Our ref: Griffith Battery Energy Storage System (SSD-85372970)

Subject: Request for Additional Information

INTERSECTION OF:
STURT HIGHWAY, TASMAN ROAD AND EUNONY BRIDGE ROAD
EAST WAGGA WAGGA

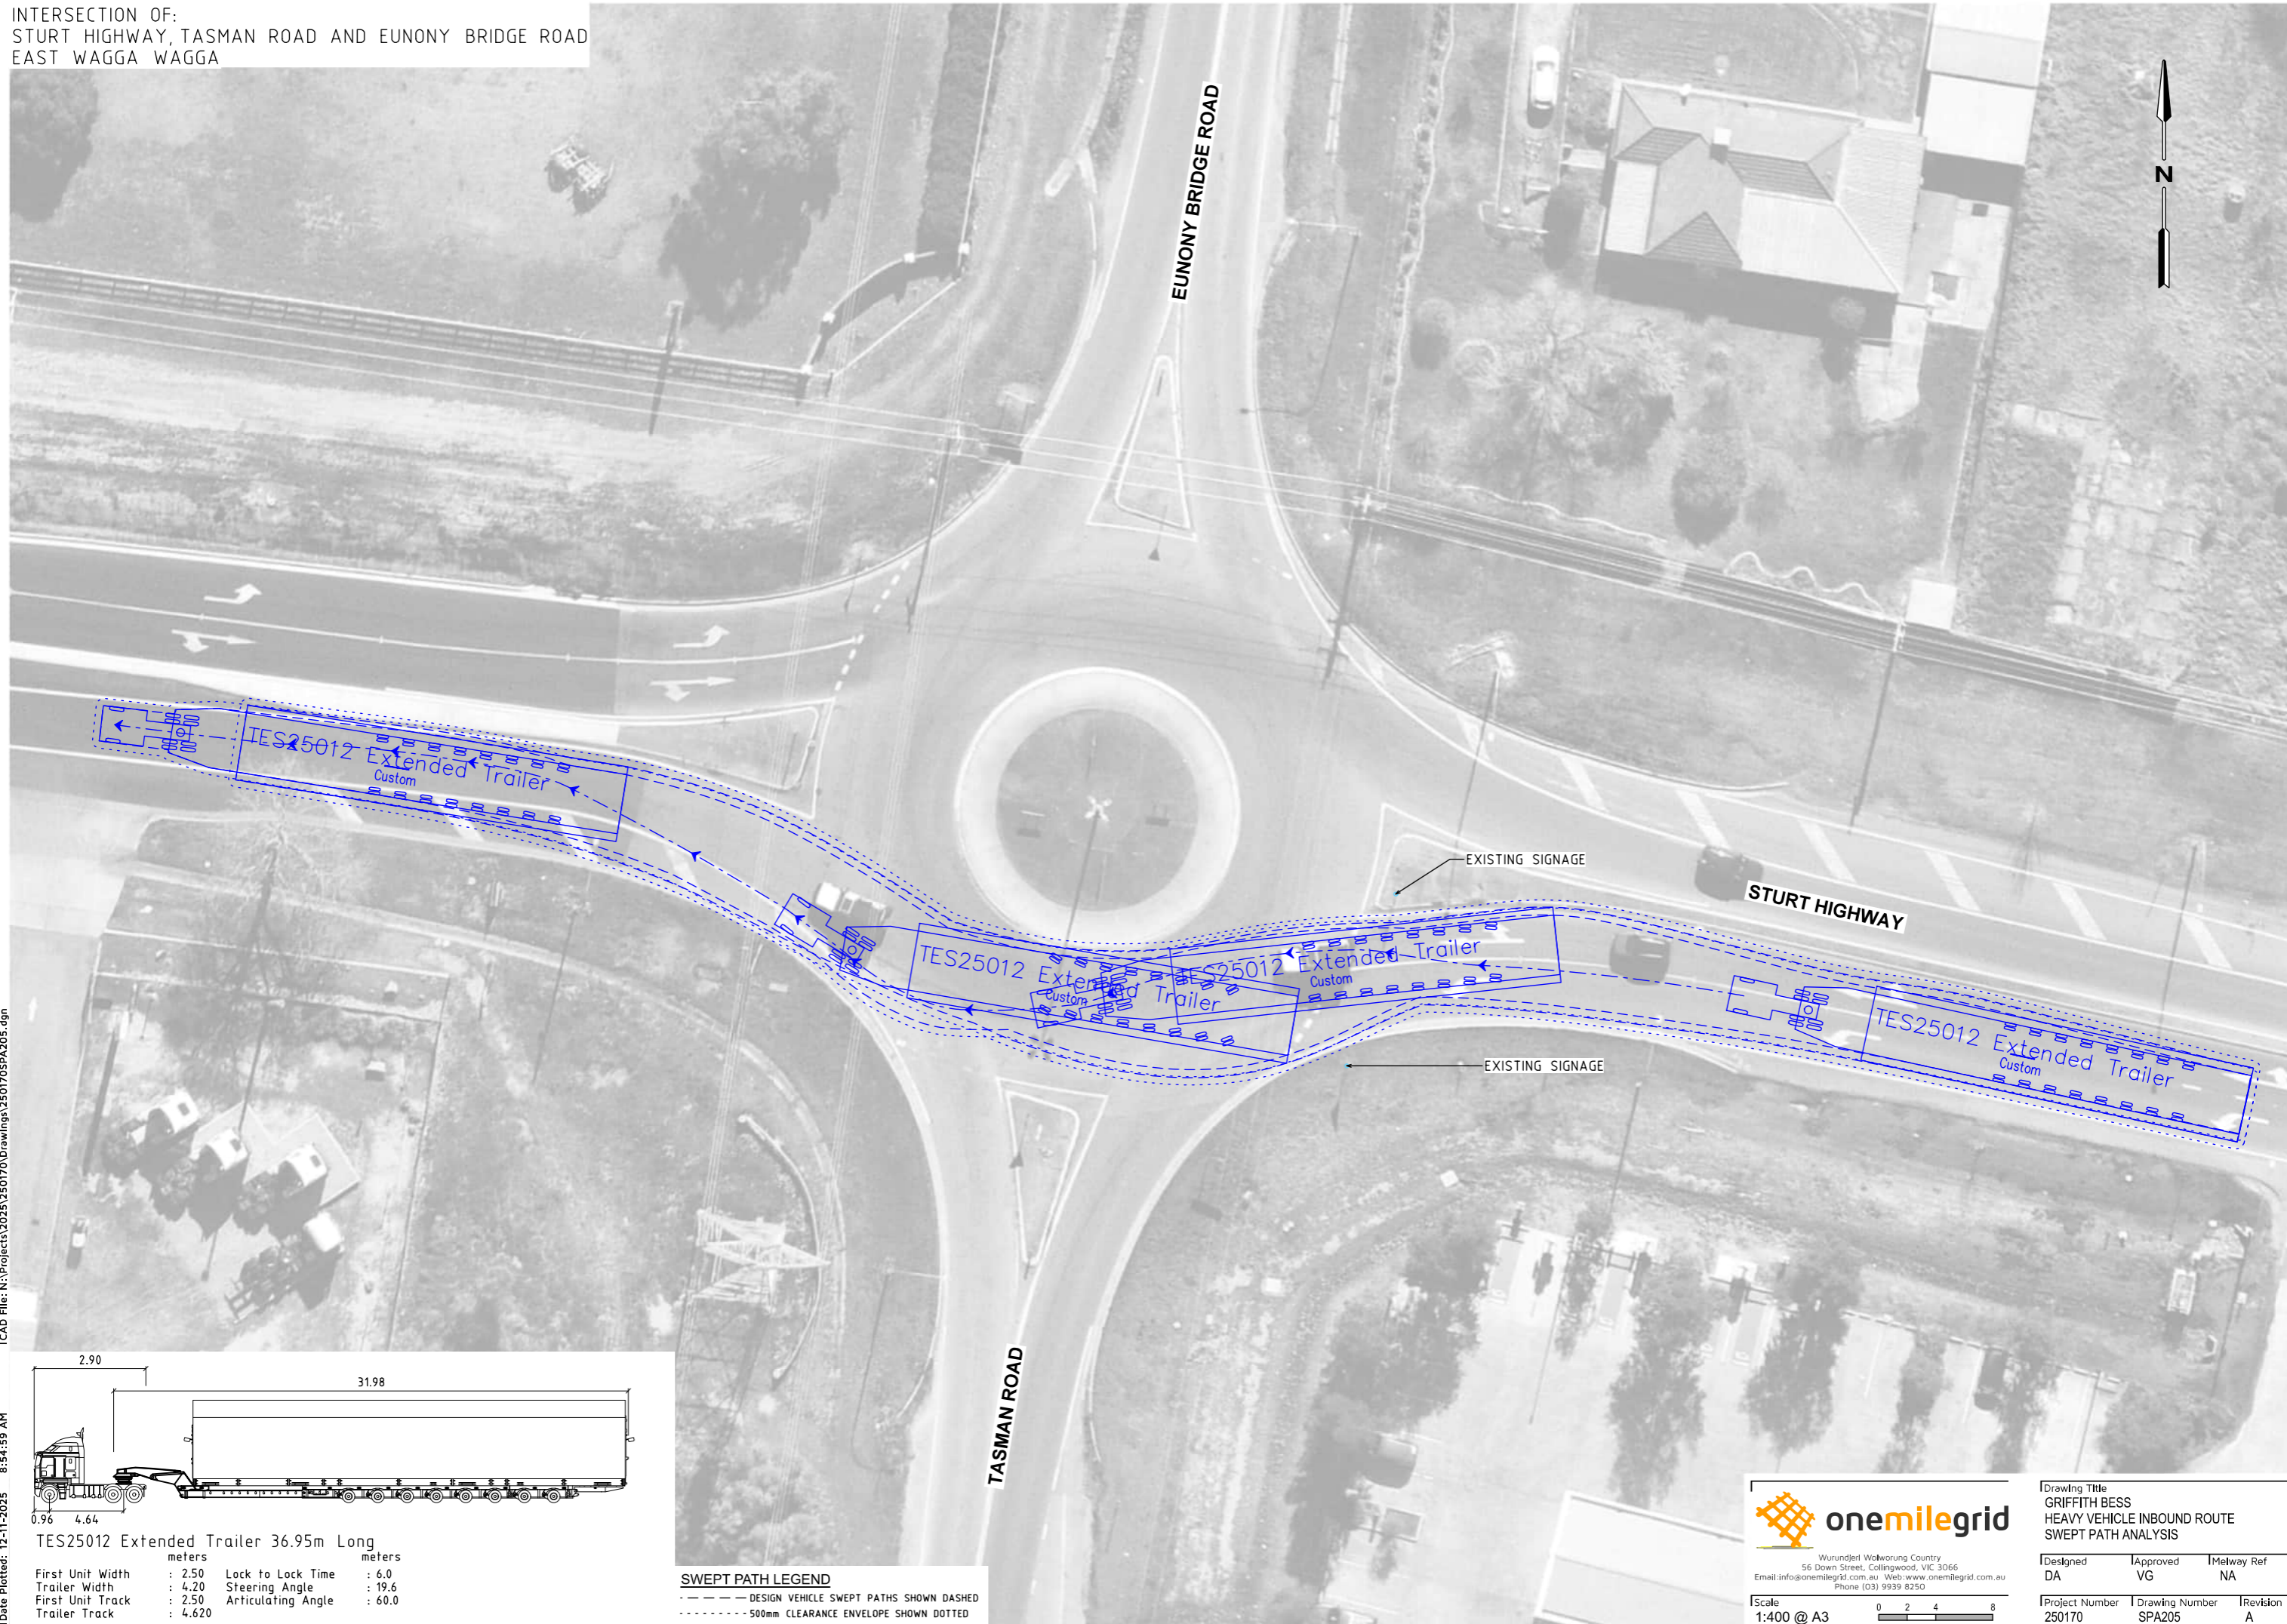
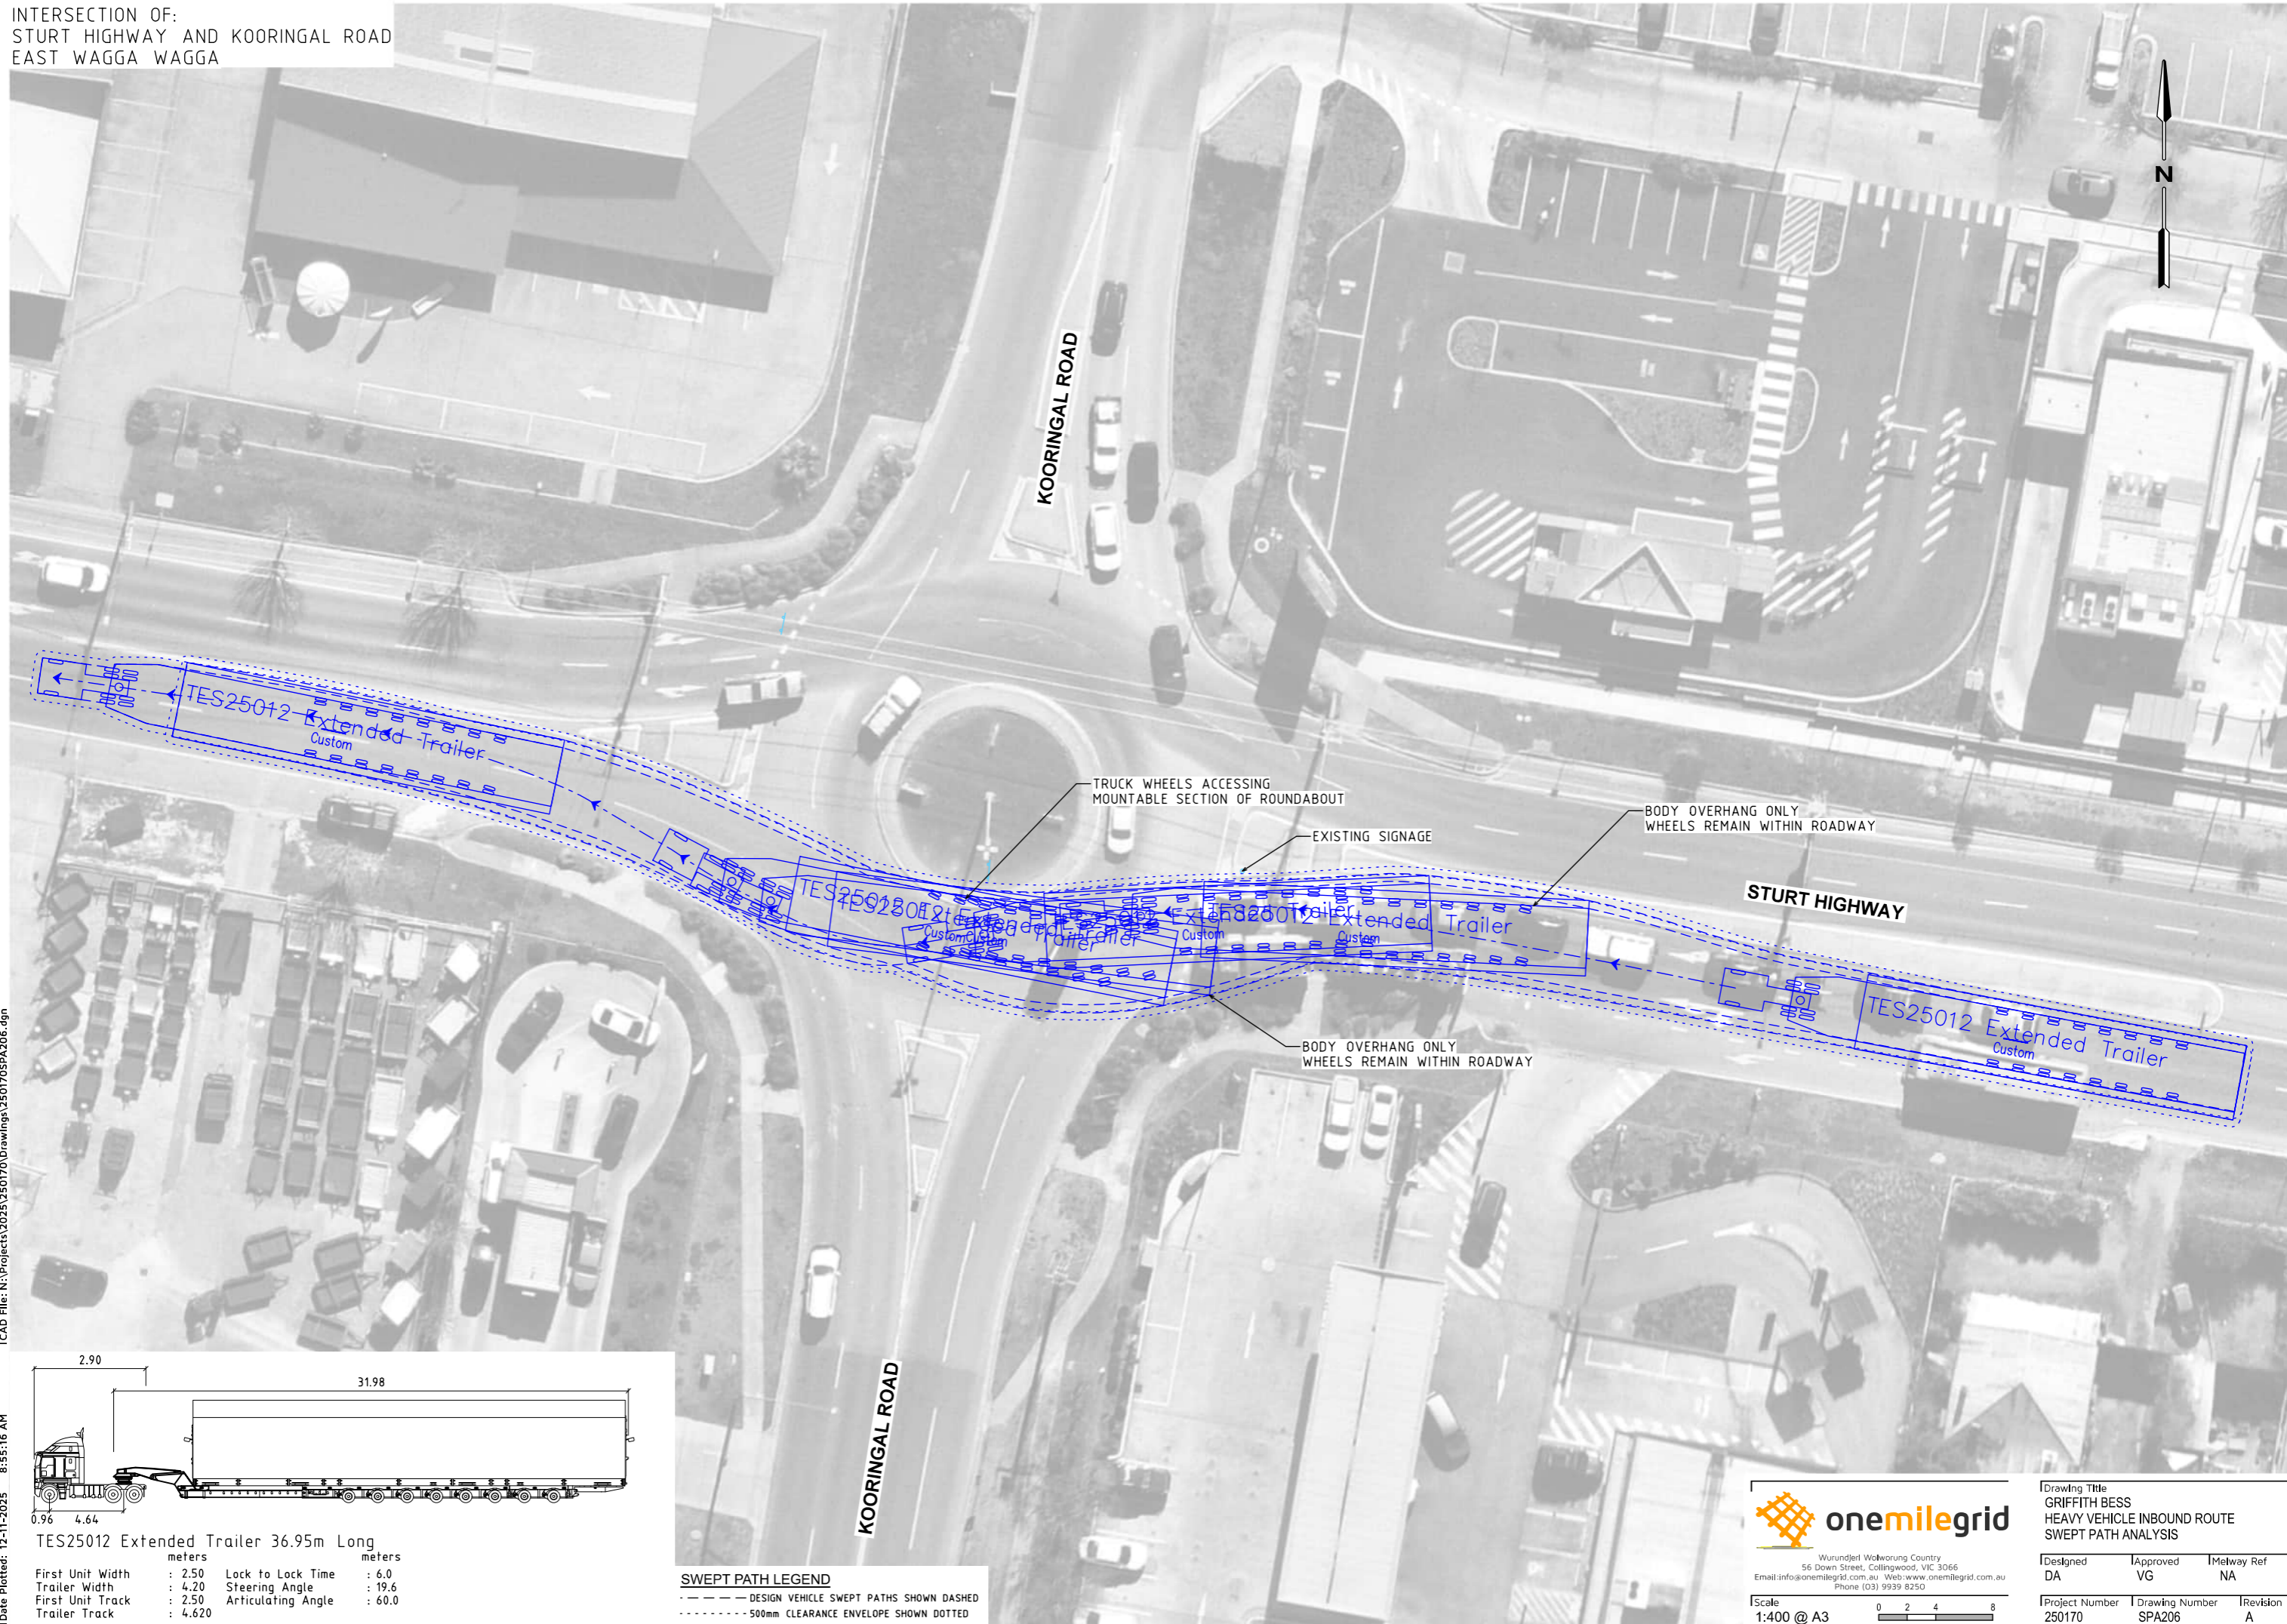
- further detail on transport and traffic matters, including:
 - o on the load capacity and dimensions (including vertical geometry) of the culverts proposed to be traversed for the heavy vehicle requiring escort and heavy vehicle haulage routes;
 - o update the swept path diagrams to identify the proposed roadworks to medians, aprons and other road structures; and
 - o clarification on the transmission line crossing Irrigation Way and on pre-construction minor works;
- further detail on the project area and site design, including on the total development footprint (in hectares), consideration of construction and equipment laydown areas for constructability, and provision of high level concept designs for the three proposed site access points; and
- provision of landowners consent for all areas with road works proposed along the haulage route.
